LOCATION 44 George St 157-B-009

MEMORANDUM

RE: Temporary Certificate of Occupancy for 44 George Street

* SITE PLAN *

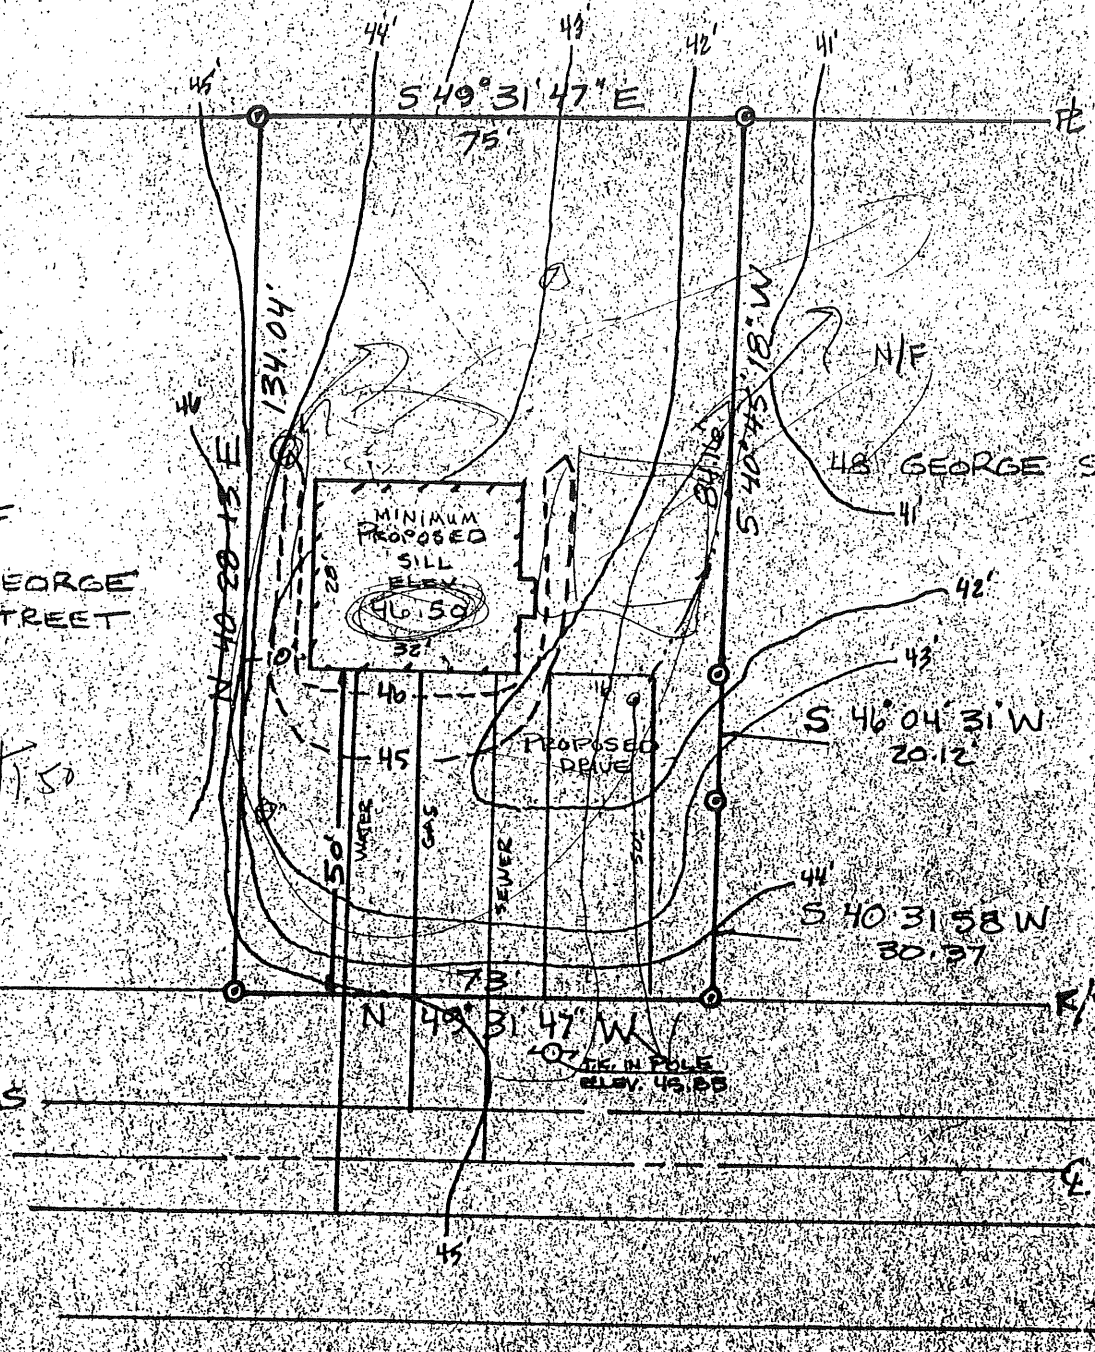
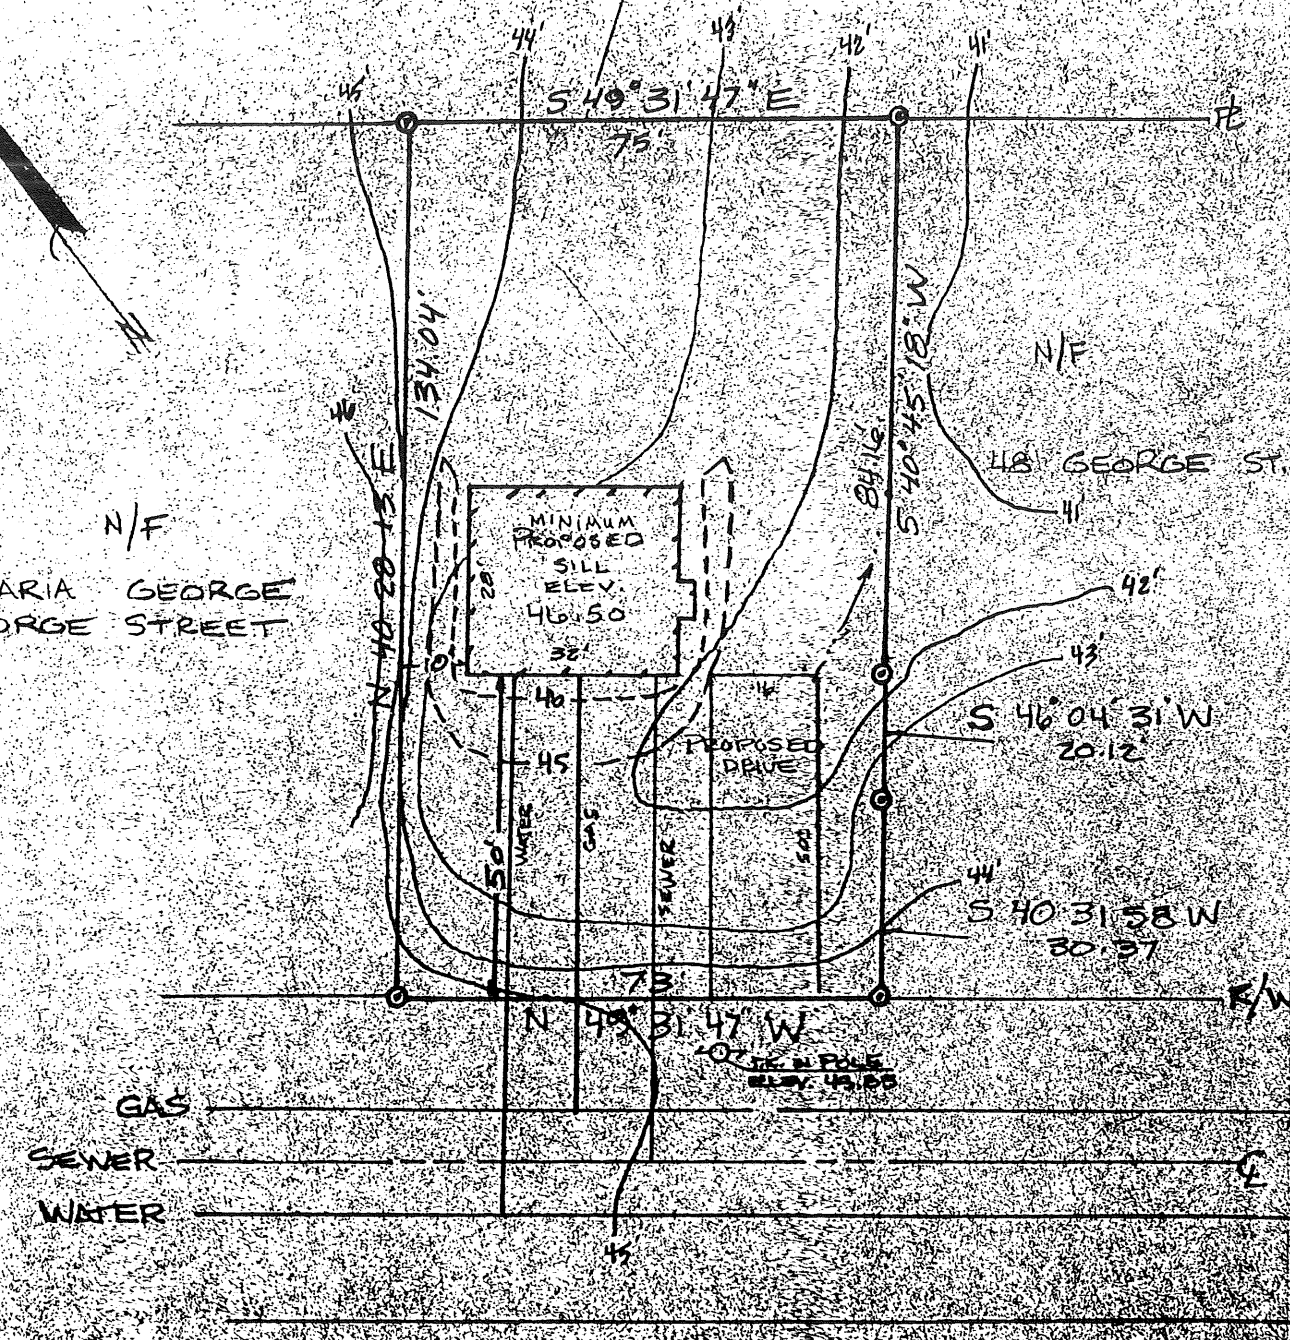
1. At the time of my inspection, the ground surface was covered with 12" of snow making it difficult to review the lot grading. It appears that lot grading may be necessary in the spring. There appears to be disturbed areas along the front and rear of the house. These areas should be filled and graded to conform to the grade as depicted on the site plan and provide positive drainage away from the house.

2. Siltation fencing at the limit of construction as reviewed by the Development Review Coordinator shall be maintained throughout the winter. If the siltation fence fails, it should be properly toed and secured by either a date when ground surface becomes unfrozen enough to install fencing or a date no later than April 1, 1996. Siltation fence may be removed once areas disturbed by construction have become 80% vegetated. All siltation fencing must be installed and maintained in accordance with the Best Management Practices (BMP's) as published by the Maine Department of Environmental Protection.

3. The disturbed lot area shall be loamed, seeded and mulched no later than May 1, 1996 and approved by the Development Review Coordinator. Areas along and between the neighboring driveway may be considered for landscaping with a hedge or low trees. This would provide excellent screening and assist concerns about erosion control. This is a suggestion and not a condition.
